National Highways Planning Response (NHPR 21-09) Formal Recommendation to an Application for Planning Permission

Council's Reference: 21/03268/OUT

Location: OS Parcel 2636, NW of Baynards House, Ardley

Proposal: Outline planning permission (all matters reserved except for access) for the erection of buildings comprising logistics (Use Class B8) and ancillary Office (Use Class E(g)(i)) floorspace; construction of new site access from the B4100; creation of internal roads and access routes; hard and soft landscaping including noise attenuation measures; and other associated infrastructure

Section 1-1 (1:250 @A1)

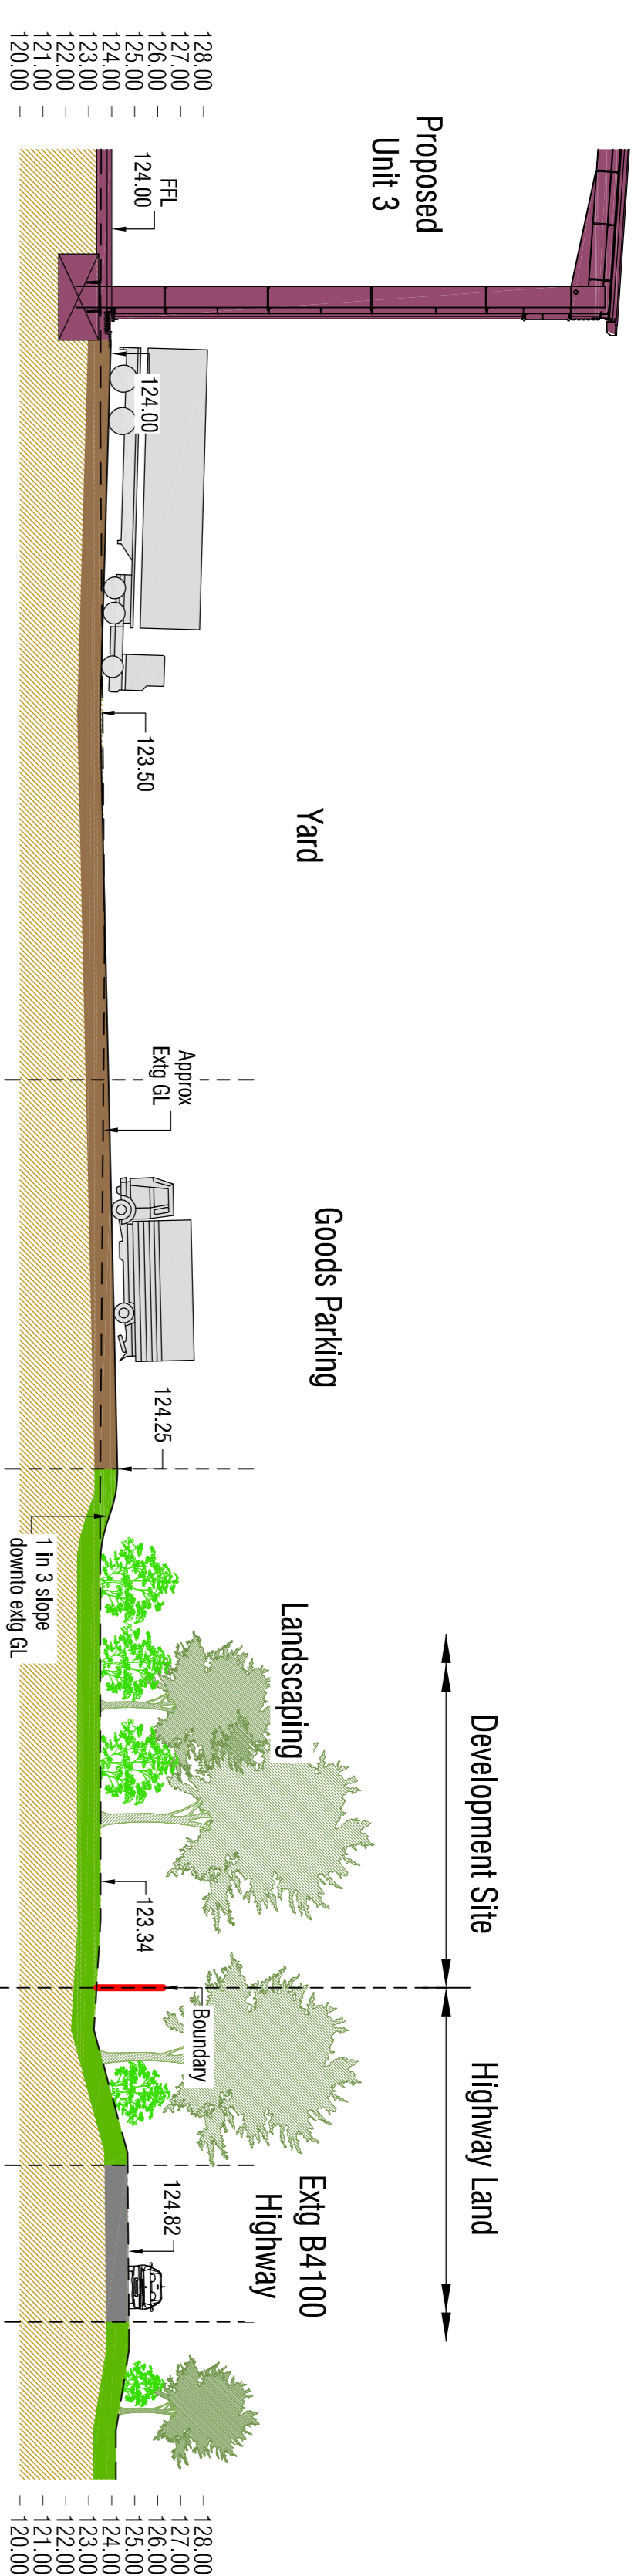
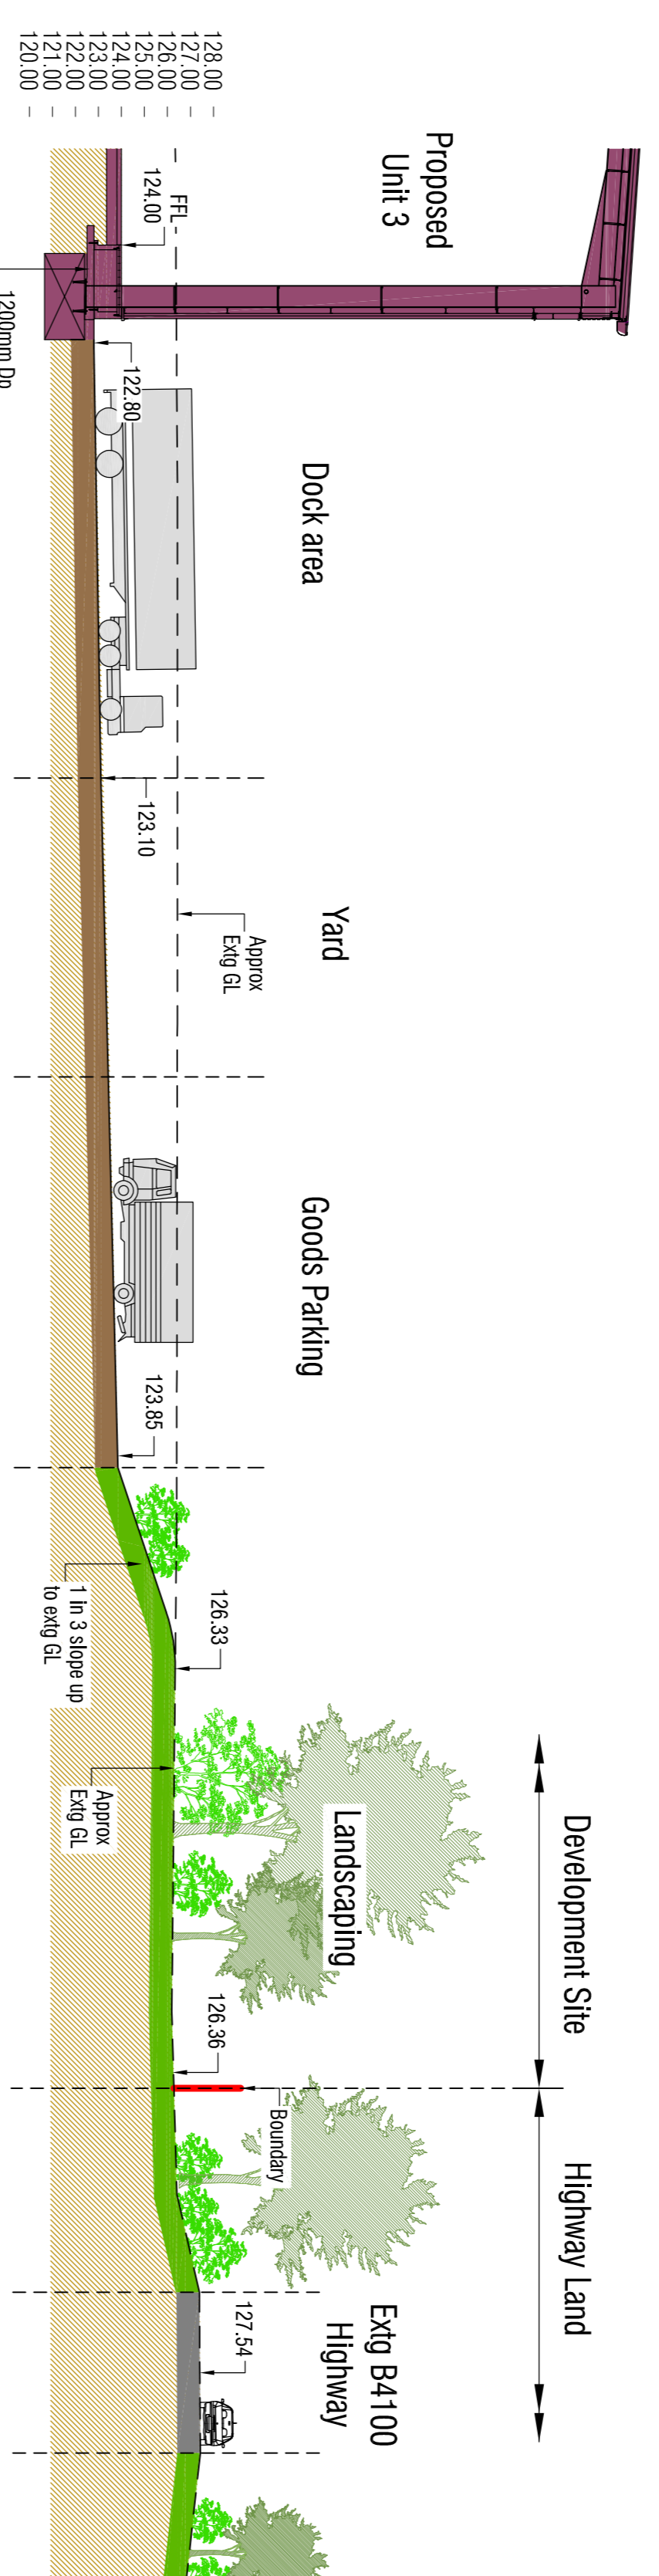
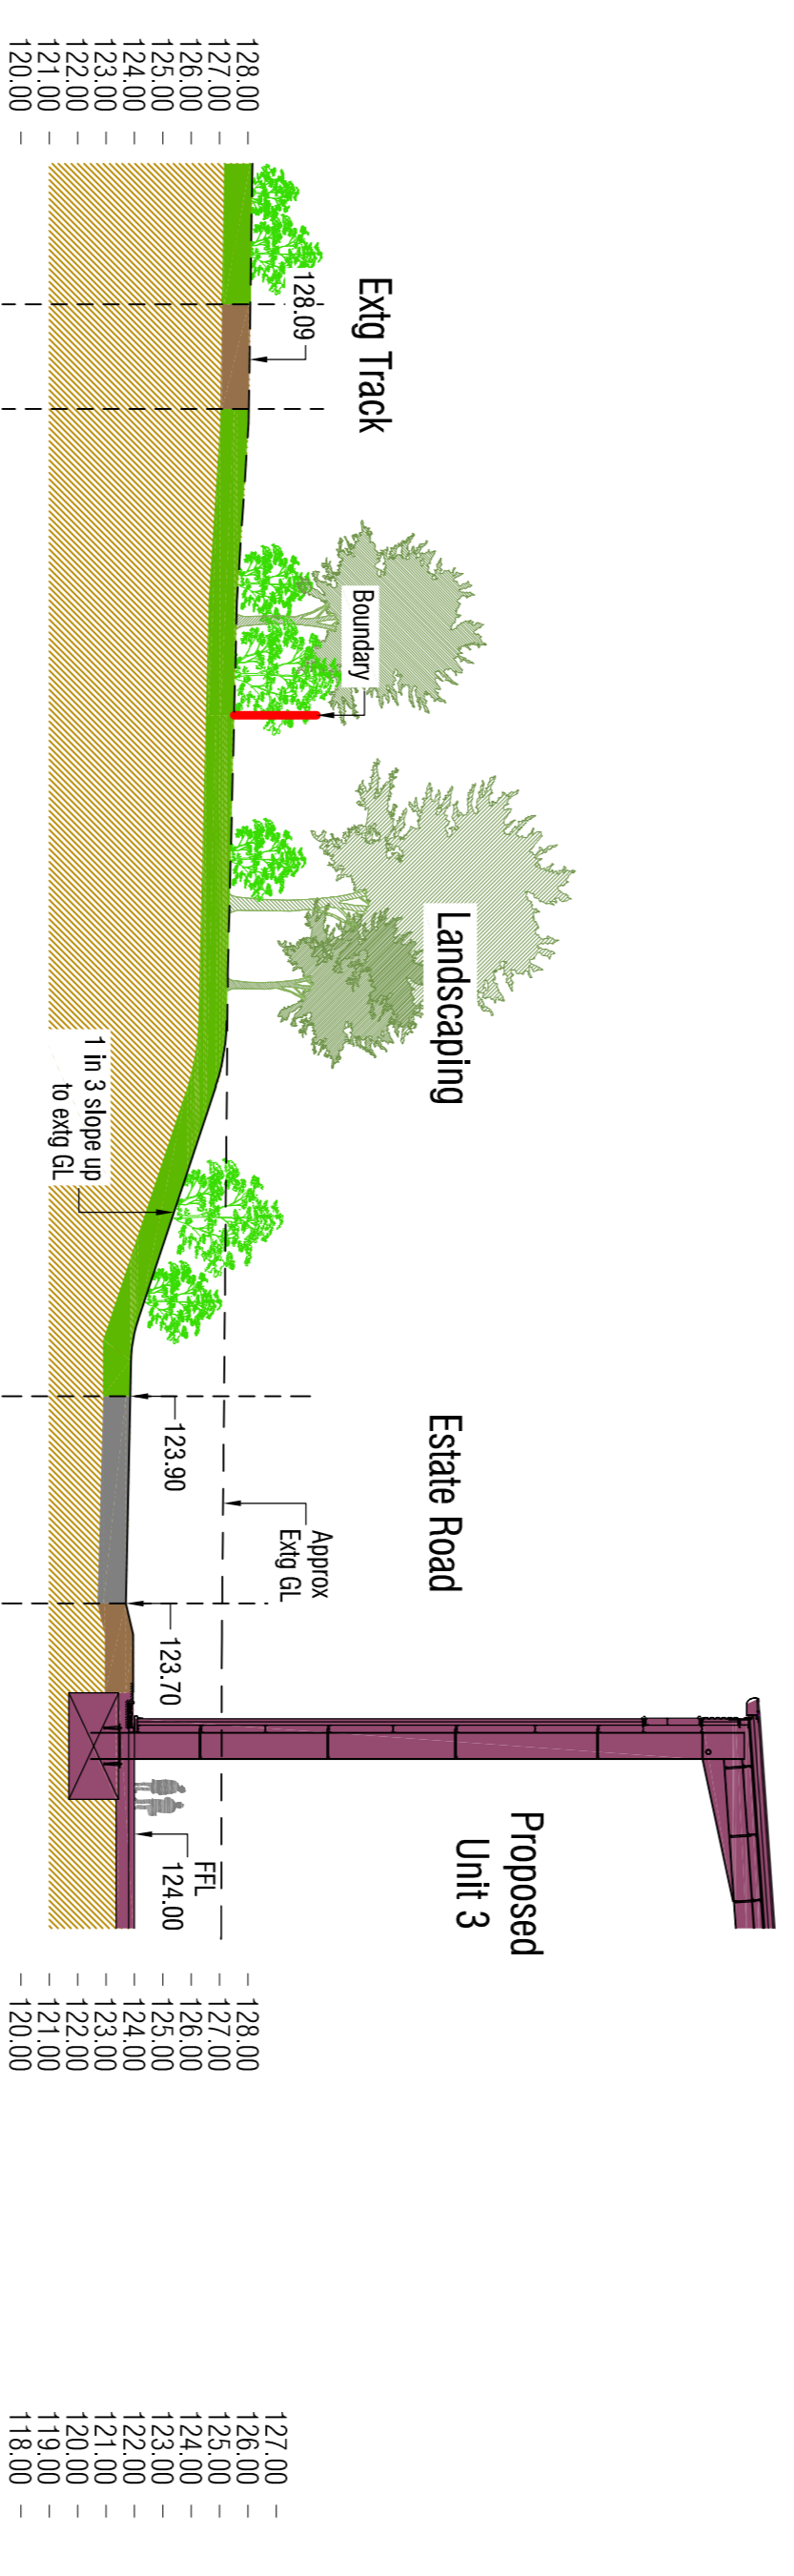
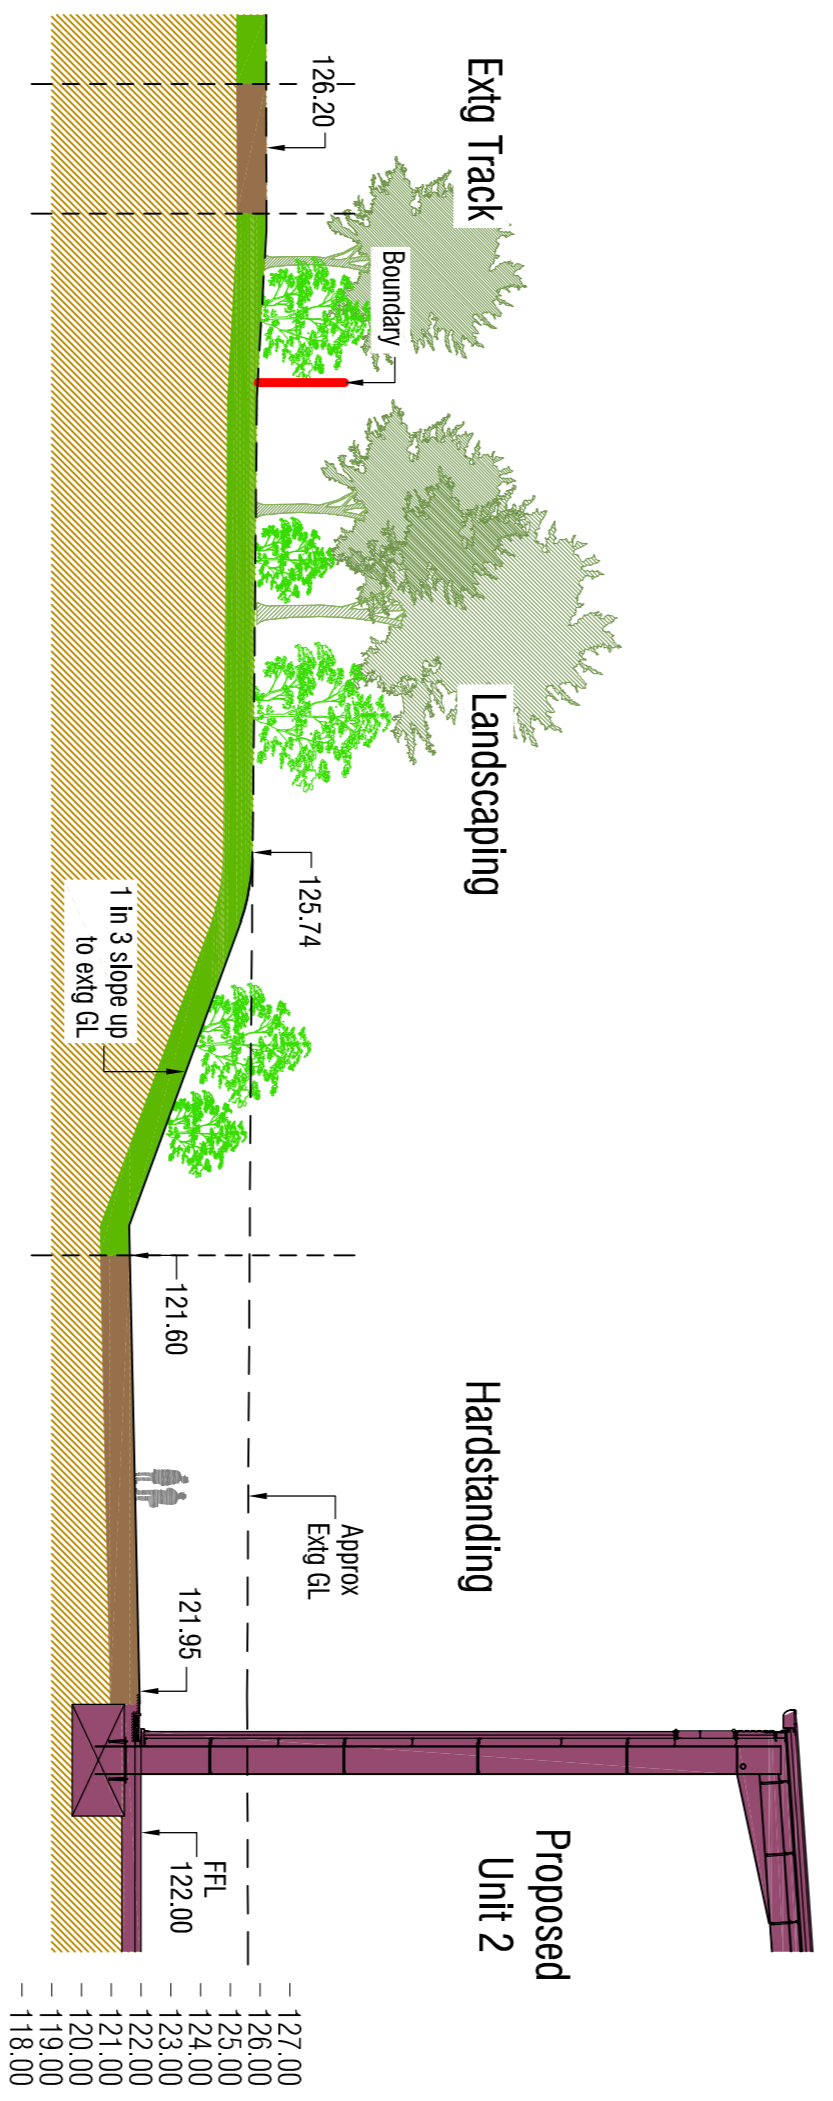
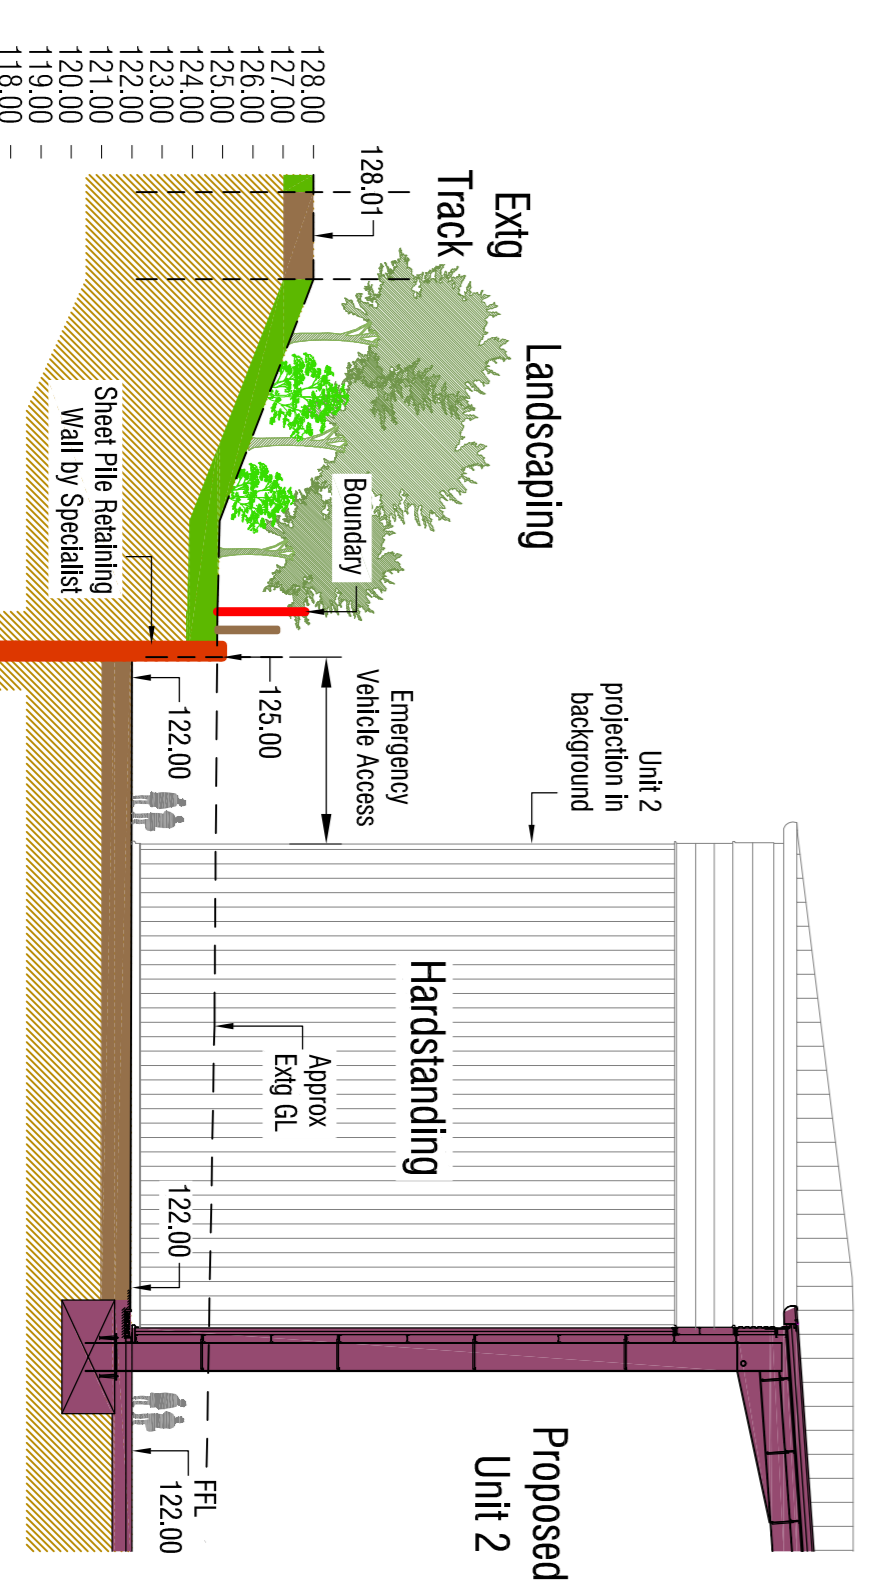
The applicant will need to advise / confirm if there will be any earthworks associated with the development(s) in relatively close proximity to National Highways boundaries (e.g. the stability of the balancing ponds, etc). In the first instance, some cross sections (to scale) through the boundaries showing the proposed extent of the development, its features and any proposed changes in elevation (excavations, landscaping) etc should be submitted for further assessment. Once received, we will review to determine the possible extent of any geotechnical reporting under the Design Manual for Roads and Bridges (DMRB) standard CD 622, which may be required to confirm the extent of any geotechnical risk to the SRN.
